From: [Rodenbeck, Jay B.](#)
To: [Brennon Williams](#); [Robert Lucero](#); mmyers@moplaw.com
Cc: [Rose, Robyn L.](#); [Gomez, Angela J.](#)
Subject: FW: Questions about the Sensitive Lands Analysis for the Major Preliminary Plat for PR-2025-020092, MAJOR_PLT-2025-00016
Date: Monday, December 15, 2025 6:55:00 PM
Attachments: [PR-2025-020092-HPtLP Slope 2025 12-15.pdf](#)

From: Rodenbeck, Jay B.
Sent: Sunday, December 14, 2025 11:54 PM
To: Angela Piarowski <angela@modulusarchitects.com>
Cc: Rose, Robyn L. <rrose@cabq.gov>; Biazar, Shahab <sbiazar@cabq.gov>
Subject: Questions about the Sensitive Lands Analysis for the Major Preliminary Plat for PR-2025-020092, MAJOR_PLT-2025-00016

Reviewing the attached Sensitive Lands Analysis included with the application submittal for the Major Preliminary Plat for PR-2025-020092, MAJOR_PLT-2025-00016, it appears the Sensitive Lands Analysis was performed for a different site than the subject property for the Major Preliminary Plat for PR-2025-020092, MAJOR_PLT-2025-00016. For example, on page 1 of the Analysis, the site is depicted as follows:

Figure 1: Aerial of Site and Vicinity.

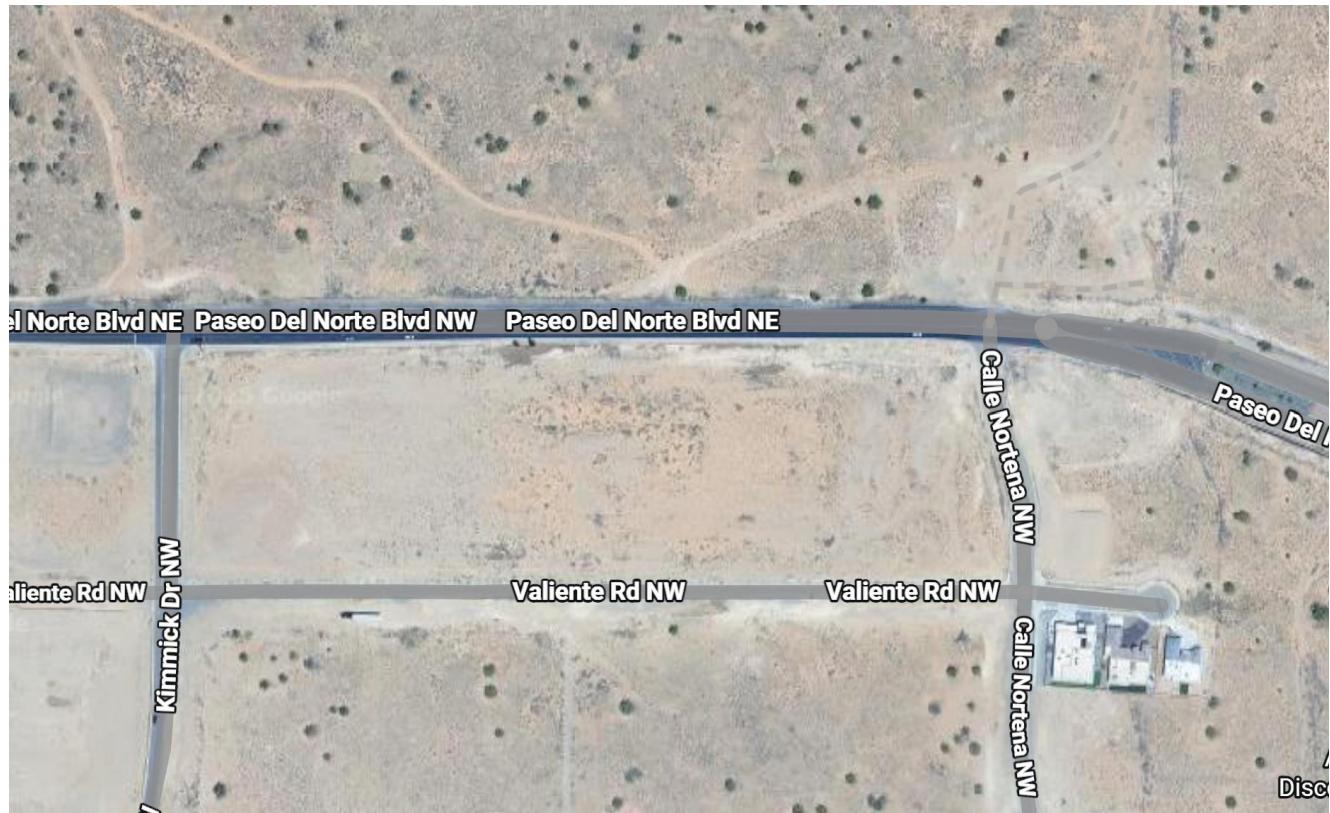
Please confirm if a Sensitive Lands Analysis was performed for the subject property for the Major Preliminary Plat for PR-2025-020092, MAJOR_PLT-2025-00016. If a Sensitive Lands Analysis has been performed for the subject property, please upload it ASAP to the application in ABQ-PLAN, and email it to me, Robyn Rose, Shahab Biazar, and Angela Gomez. If a Sensitive Lands Analysis has not been performed and completed for the subject property yet, then it will need to be performed and completed and confirm that no sensitive lands are present on the subject property or can be avoided by the proposed development before the DHO would be able to approve the noted platting application. Additionally, if the Sensitive Lands Analysis confirms that the proposed development cannot avoid sensitive lands pursuant to 5-2(C)(2) and 5-2(C)(3) of the IDO, a Site Plan – EPC would be required to be approved prior to the approval of the Major Preliminary Plat by the DHO.

Please see our final exhibit regarding the Sensitive Lands Slope, this exhibit was prepared by our Surveyor. As you can see, they analyzed the overall slope and provided slope percentages for the site which demonstrate that our site is well below the 9% sloping criterion.
